From: Paul Cann <Paul.Cann@arun.gov.uk>
Sent: 19 March 2020 11:37
To: Planning.Responses <Planning.Responses@arun.gov.uk>
Cc: Sarah Burrow <Sarah.Burrow@arun.gov.uk>; Amy Myer <Amy.Myer@arun.gov.uk>
Subject: RE: Planning Consultation on BE/17/20/DOC

APPLICATION NO: BE/17/20/DOC

Site Address: Site 6 Chichester Road North Bersted

Description of Works: Approval of details reserved by condition imposed under BE/84/19/PL relating to conditions 3-surface water drainage, 10-facilities to enable charging of electric cars & 11-incorporation of decentralised, renewable & low carbon energy supply systems.

DRG No. S814/Ph4c/01	REV. G
-------------------------	-----------

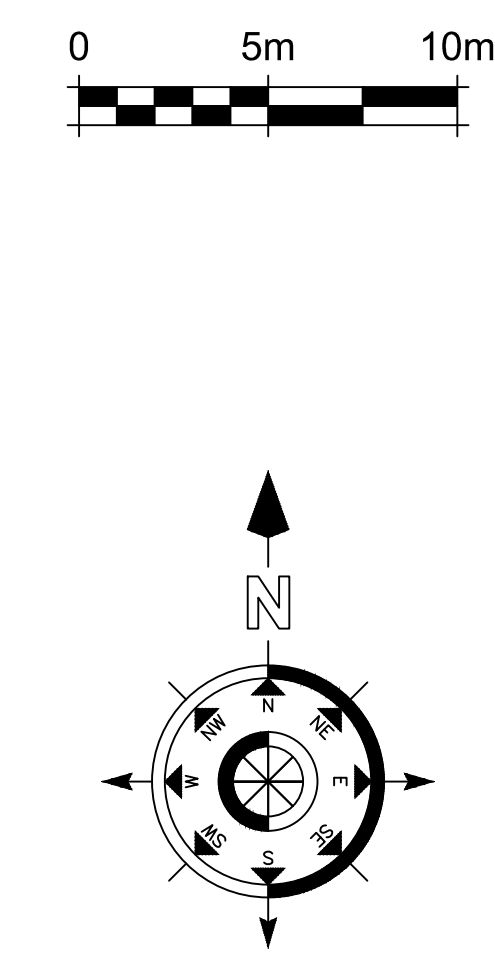
Engineers comments on surface water proposals, based upon the area of development shown within the red line on drawing S814/Ph4C/01 Rev G;

1. It is recognised that this area was included in the overall master plan to discharge to the already constructed suds system and therefore additional storage is not required.
2. Numerous channel drains in the vicinity of plots 336a to 338a, do not show connectivity to the surface water drainage system.
3. RWP on plot 336b does not show connectivity to the surface water drainage system.
4. All connections to pipelines not made direct to manholes to be connected via oblique 45 degree junctions (add note).
5. Construction detail drawings are required. These are to include details for manholes, channel drains, gullies for roads and car park area, rodding eyes, pipe bedding, etc.

Look forward to receiving revised drawings, etc.
